NSW RURAL FIRE SERVICE

Your reference: SSD 7198
Our reference: S09/0054
DA09121865907 PC

Residential Subdivision (SSD 7198) - Lot 1 DP 1097743, Pacific Highway, Moonee Beach

Attachment A
Revised Subdivision Plans – Civiltech

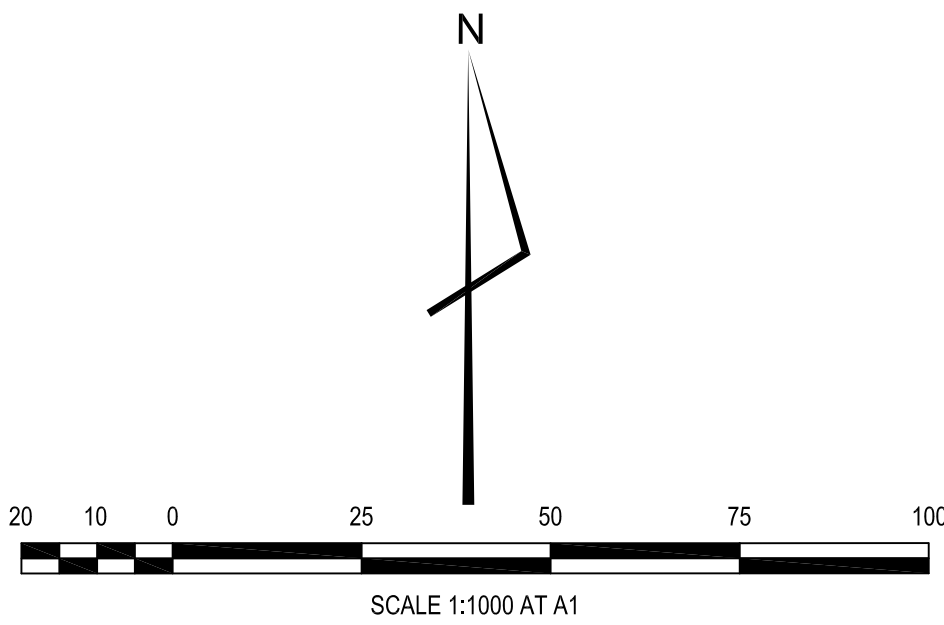
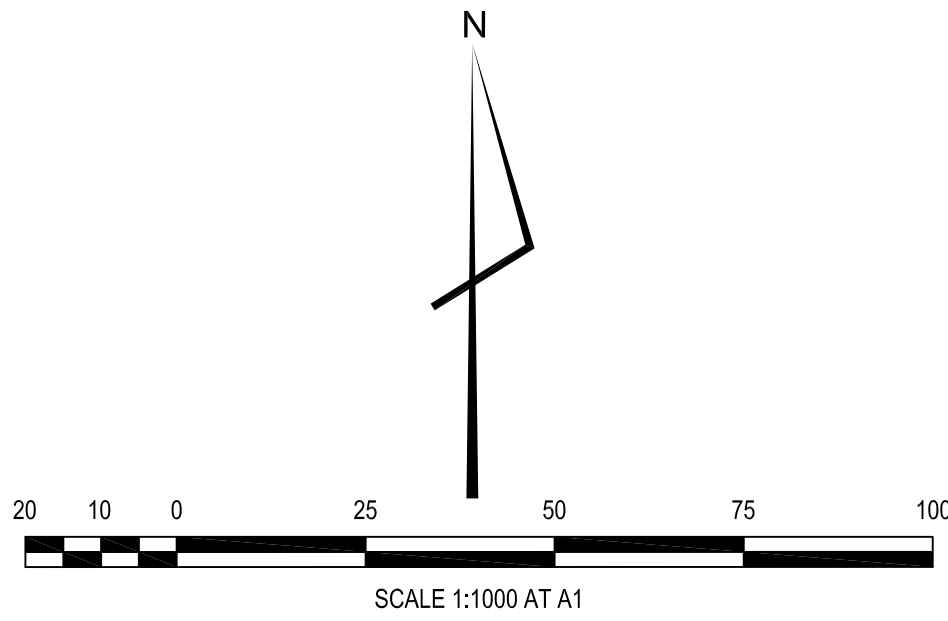
The NSW RFS has reviewed the plans and documents submitted in the Response to Submissions and is satisfied that the applicant has addressed the matters outlined in our letter to NSW Planning and Environment dated 3 December 2014, except that the proposed asset protection zone over part of Lot 104 should be managed as an inner protection area.

1. The development proposal is to comply with the subdivision layout identified on the drawing titled 'Proposed Subdivision Lot Layout', prepared by CivilTech (ref: Dwg. No. 1277-DR1 - Issue F), dated 26 August 2015, except as modified by the following conditions.

4. At the issue of subdivision certificate including Lot D104, a restriction to land use pursuant to section 88B of the 'Conveyancing Act 1919' shall be included over Lot D104 for the purpose of an asset protection zone as shown on the plan titled 'Proposed Subdivision Lot Layout', prepared by CivilTech (ref: Dwg. No. 1277-DR1 - Issue F), dated 26 August 2015. The APZ shall be managed as an inner protection area (IPA) as outlined within section 4.1.3 and Appendix 5 of 'Planning for Bush Fire Protection 2006' and the NSW Rural Fire Service's document 'Standards for asset protection zones'.
